An Coimisiún Pleanála	Record of Meeting ABP-315157-22
--	---

Case Reference / Description	Proposed development of Garryhinch Windfarm consisting of between 10 and 14 no. wind turbines with power rating of between 5.0MW to 7MW. Garryhinch Bog and Garrymore Bog, Co. Offaly and Co. Laois.		
Case Type	Pre-application consultation		
1st / 2nd / 3rd / 4th Meeting	2 nd Meeting		
Date	29 th January 2026	Start Time	11:30am
Location	MS Teams	End Time	1:30pm

Site Access – N80

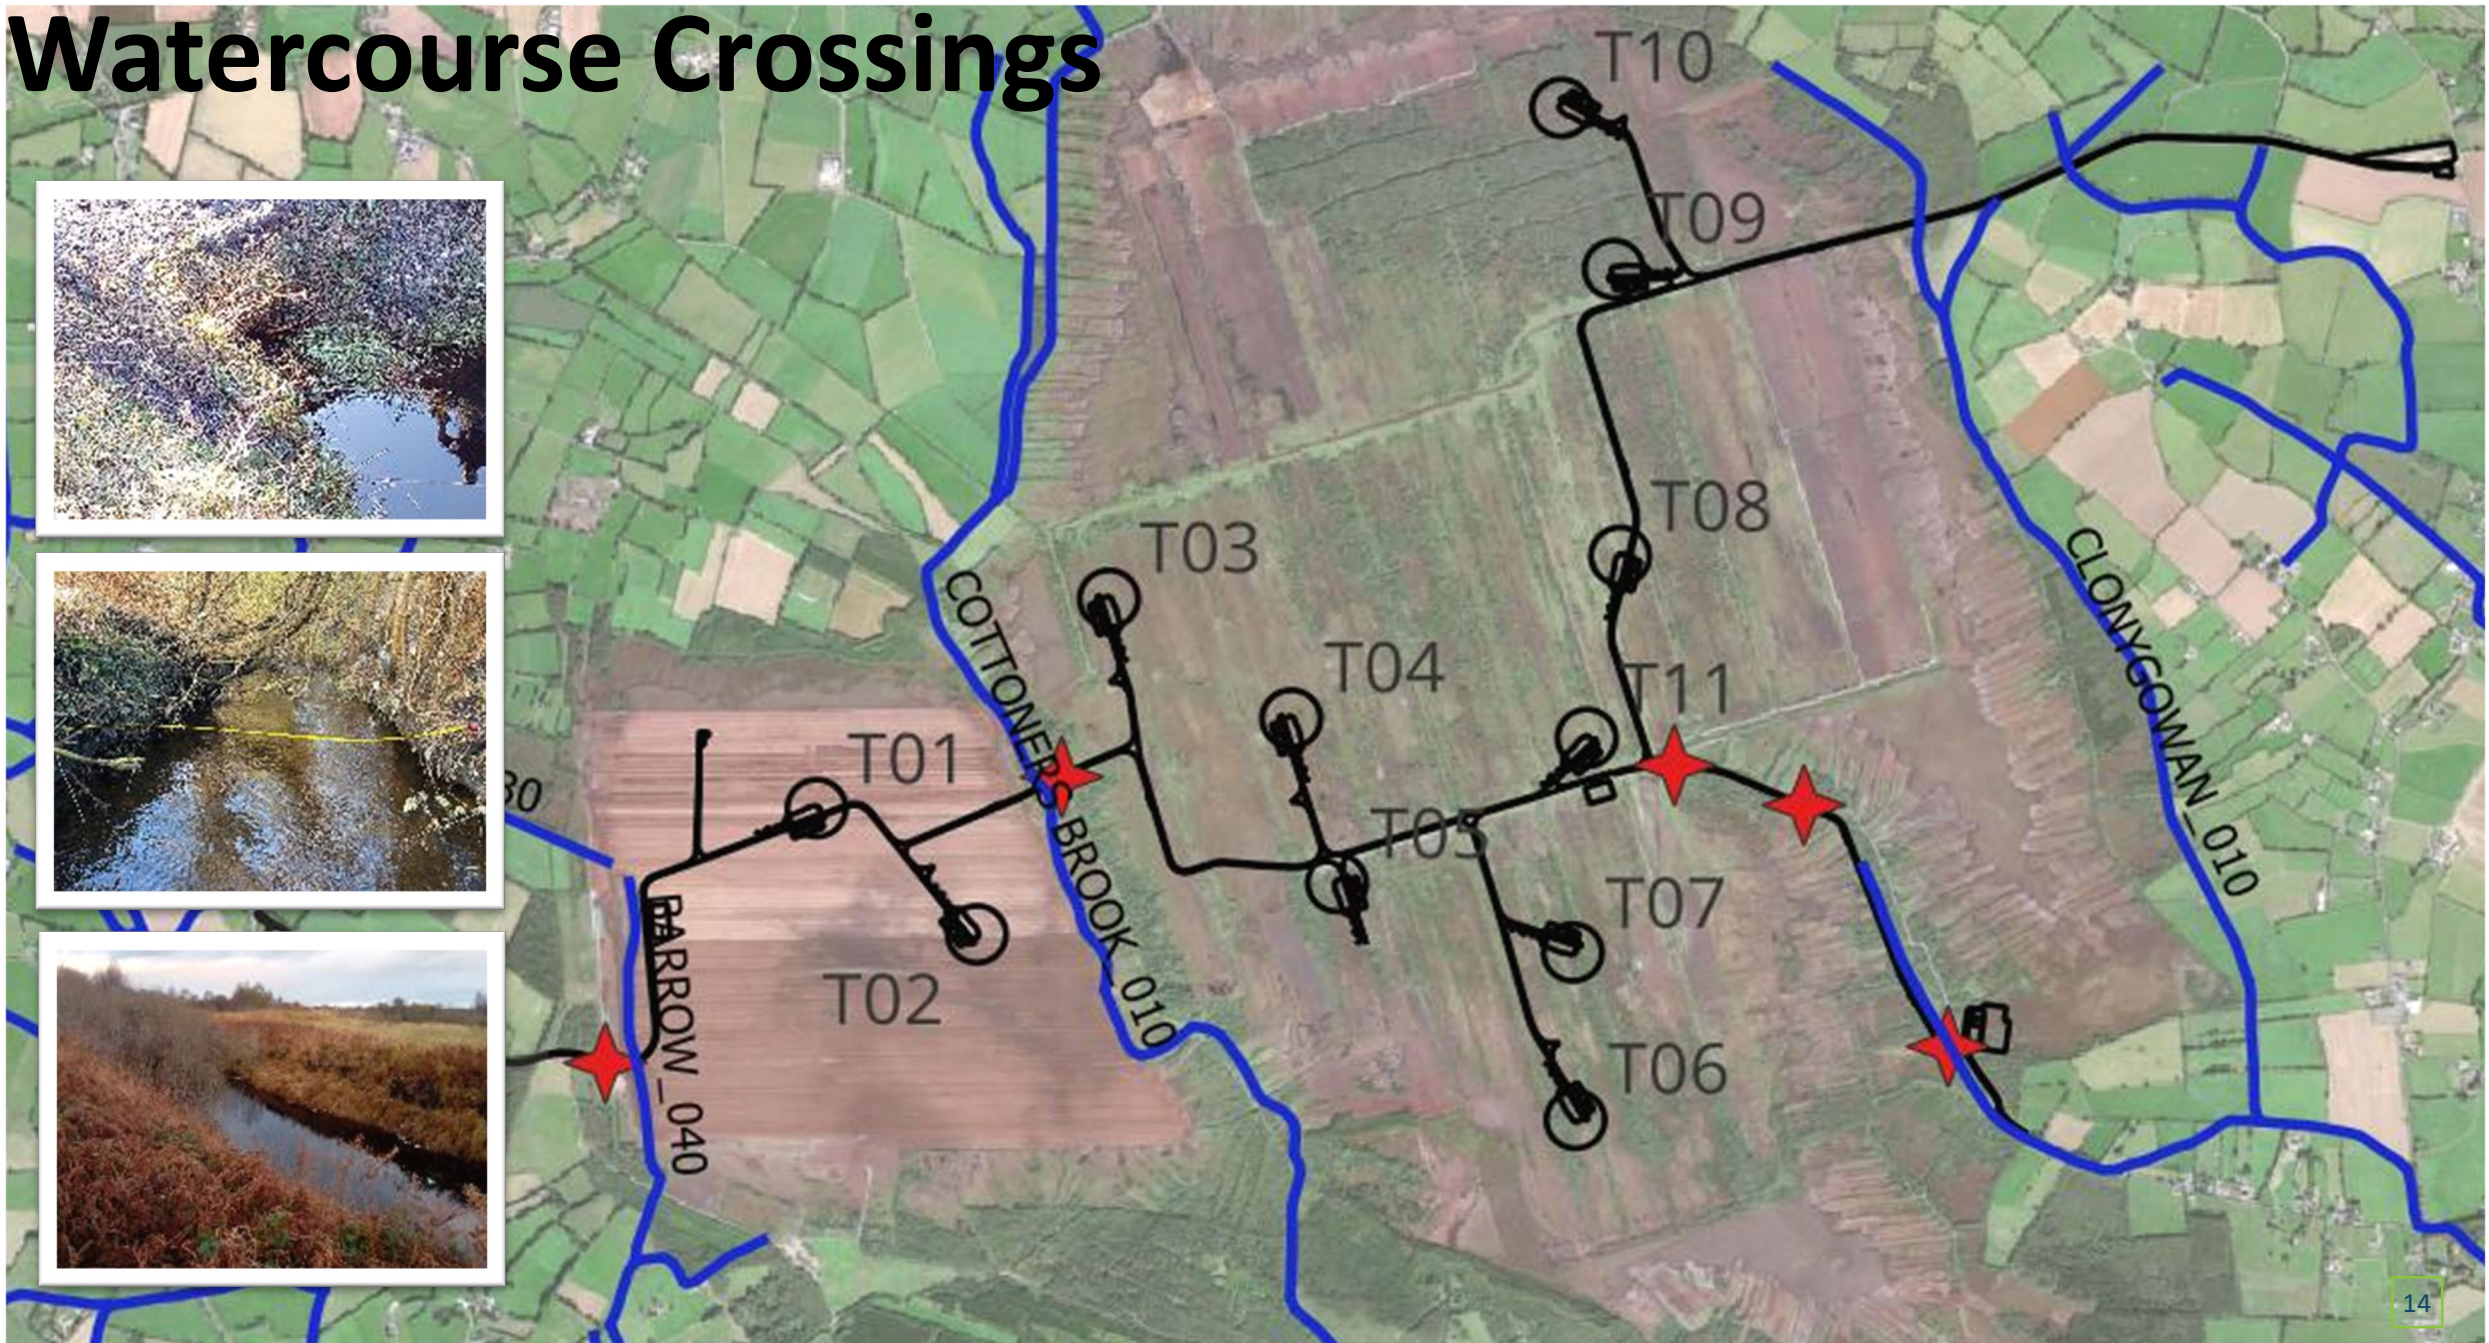
- There was some discussion regarding the location of the site relative to the permitted Dernacart windfarm. Noting the proximity of the 2 no. entrances, it was questioned whether consideration had been given to the consolidation of the entrances and access tracks. It was noted that there are a number of residential receptors within close proximity of the permitted and proposed entrances, and it was advised that the potential for cumulative impacts should be carefully considered.

- In terms of access, the Commission's representatives noted that feedback from TII regarding the entrance from the N80 was critical. The prospective Applicant noted that scoping feedback had been received. However, it was stated that this feedback was very general.

Borrow Pit

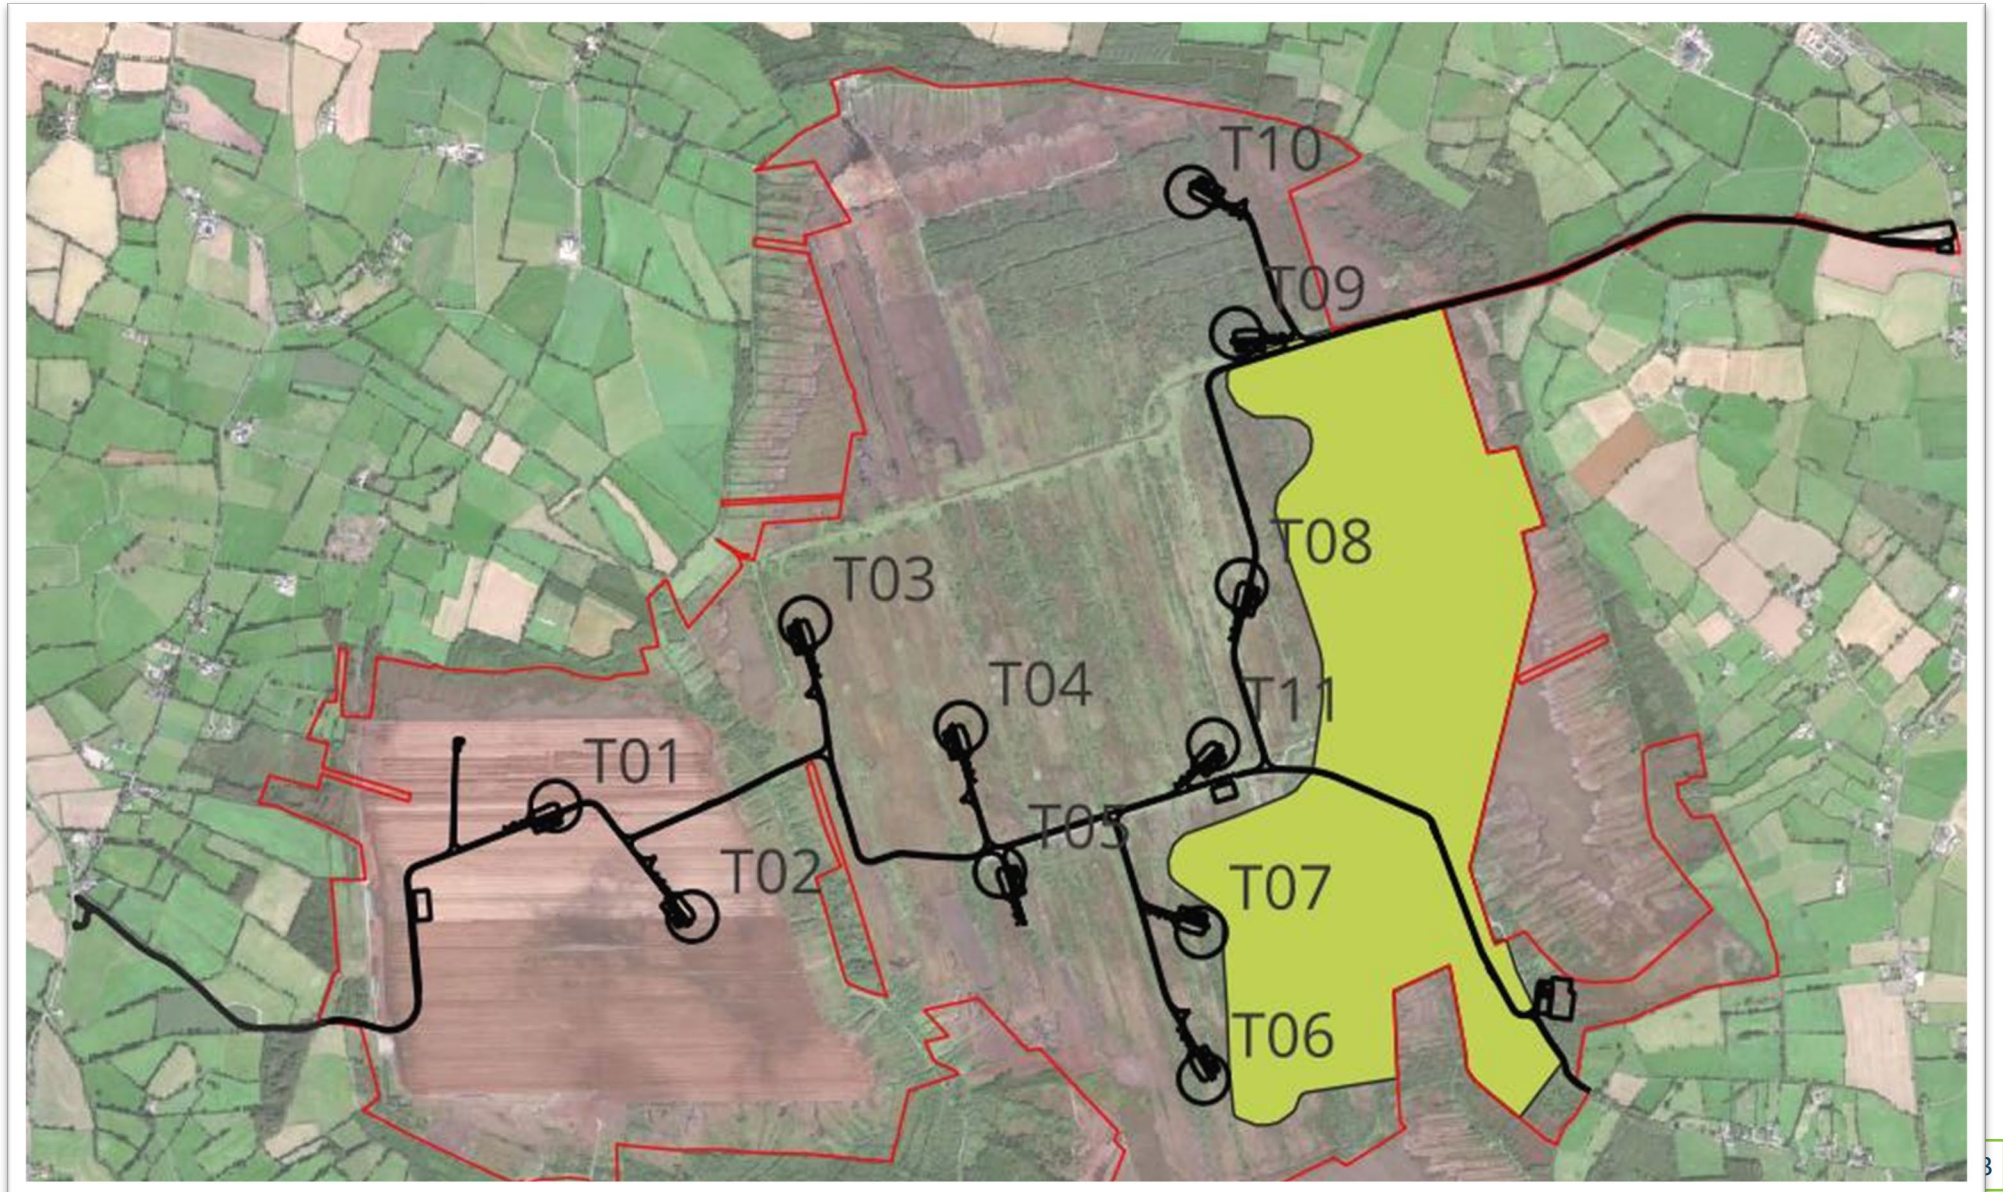
- Detailed proposals should be provided with respect to the borrow pits and peat storage areas with respect to dewatering, water management and pollution control. An assessment of potential risks associated with dewatering, including impacts to groundwater and sensitive habitats.

Noise

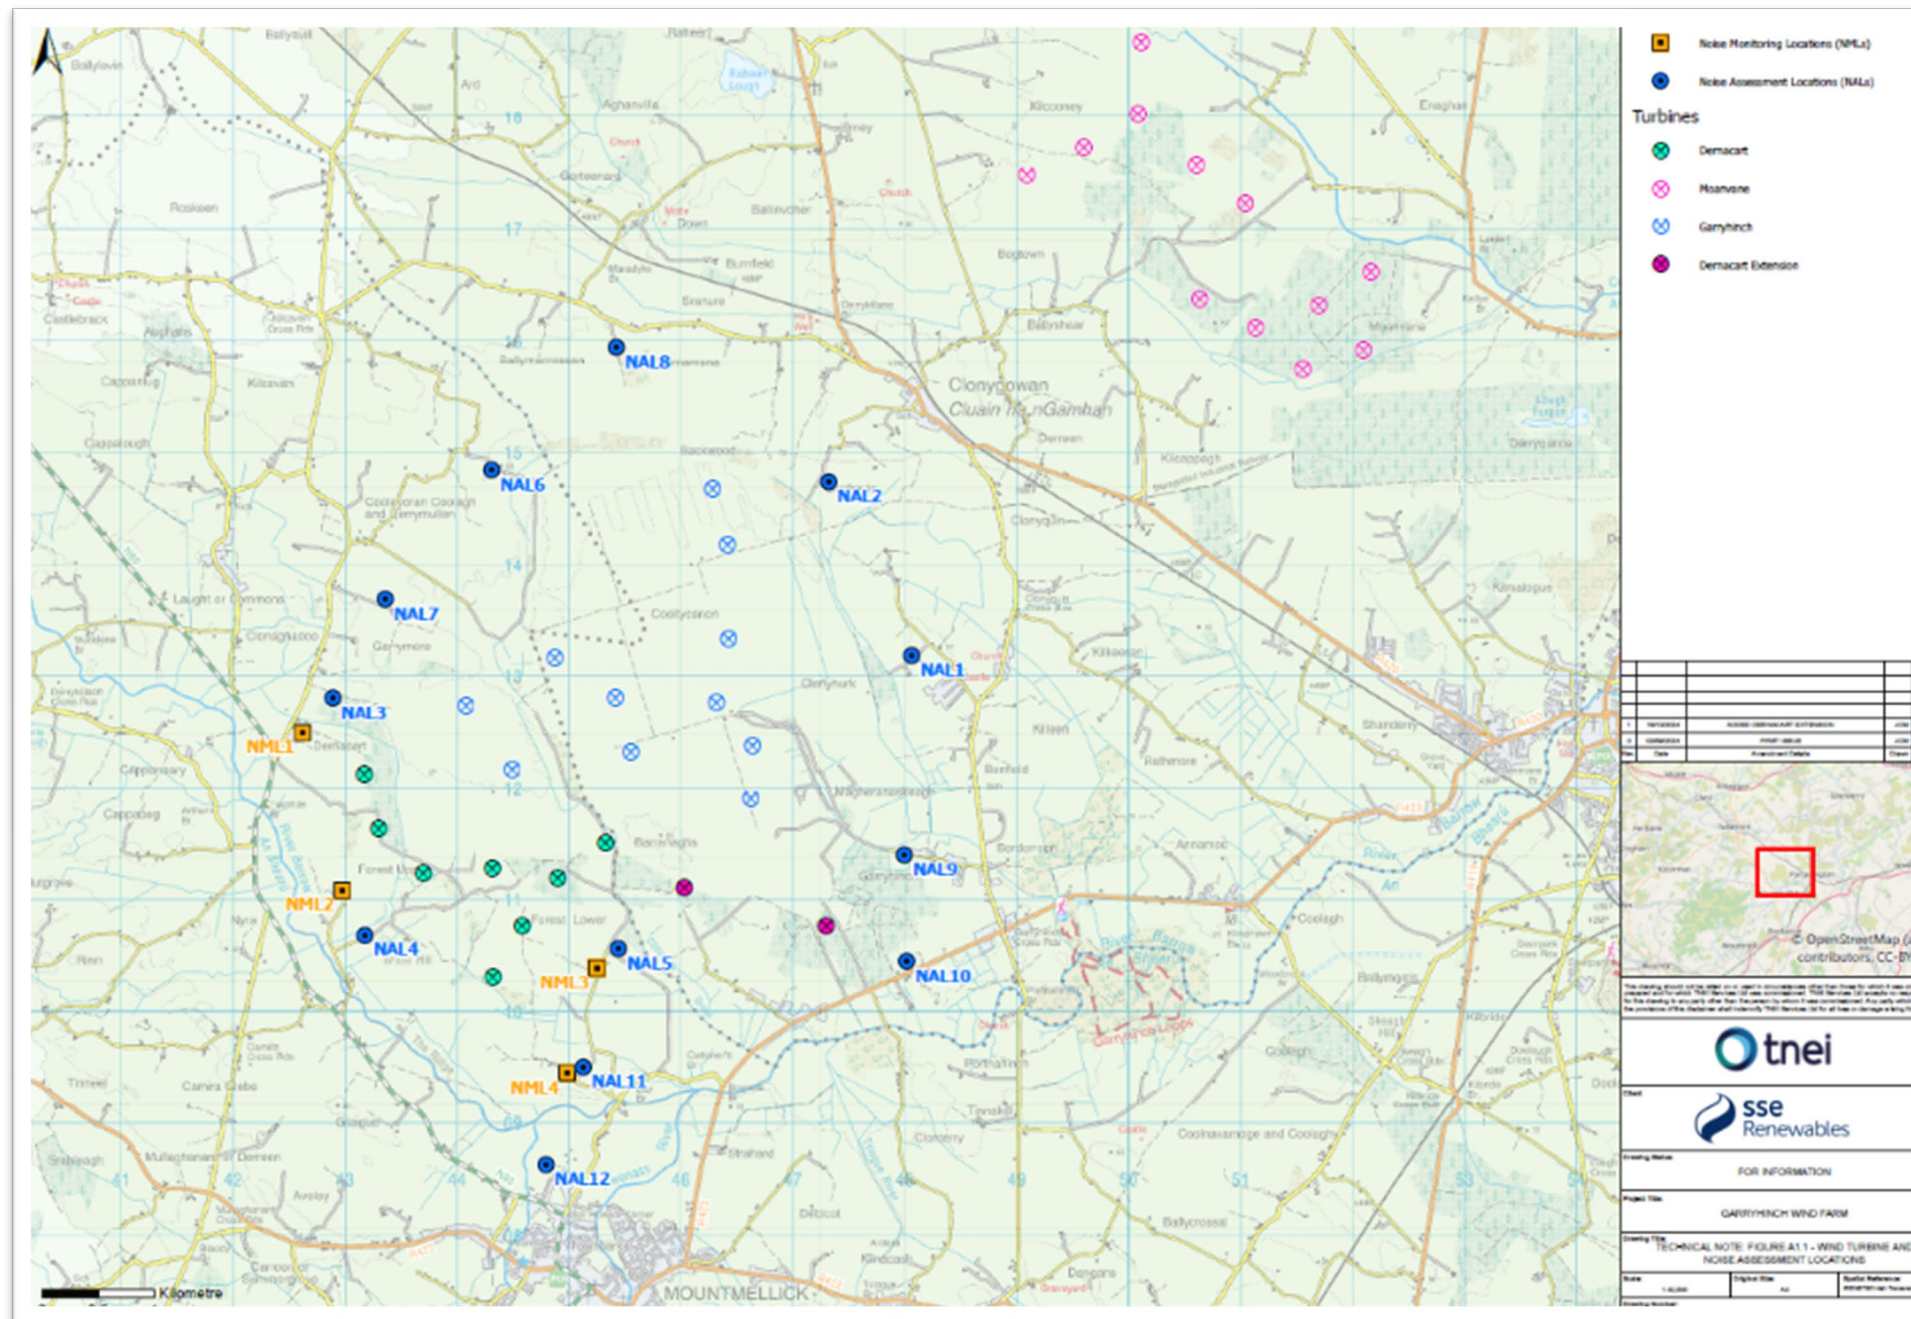
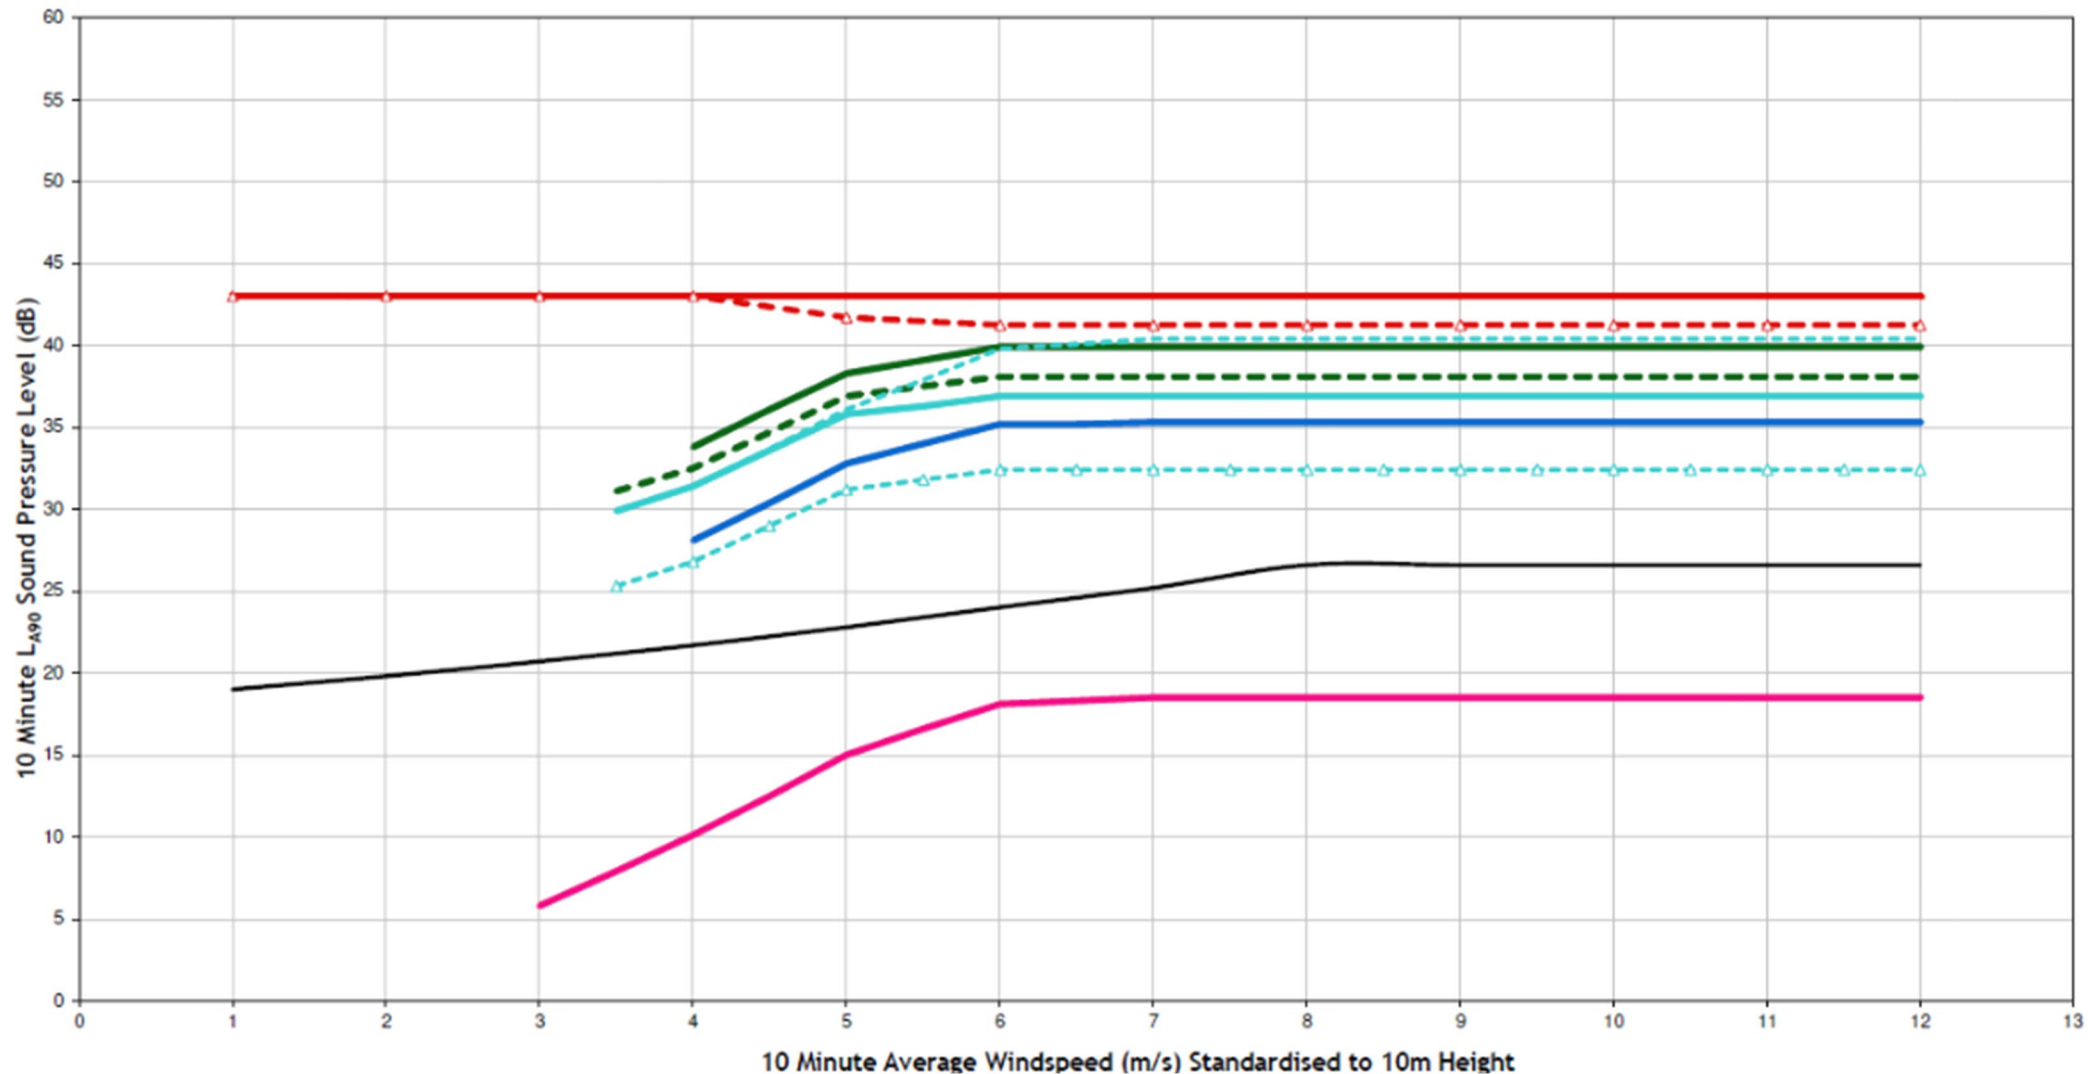
- The Commission's representatives queried the noise model being used and whether it was still the most up to date modelling for such noise.
- The prospective Applicant's presentation referred to the predicted cumulative noise meeting the WEDG limits. It was queried whether there were any exceedances regarding the proposed limits (day or night) at any of the SSNL's? If so, it was questioned what curtailment procedures would be put in place and how this would work into the day to day management. The Commission's representatives noted that this is something that would need to be robustly addressed as part of the Noise chapter.

- The Commission's representatives questioned if there were any low background noise environments below 30dB(A) found. If so, it was noted that a robust justification for the proposed limits should be presented.

- The Commission's representatives questioned whether a mitigation plan to address Noise character (AM and Tonal) would be included in the noise chapter which may arise due to complaints?
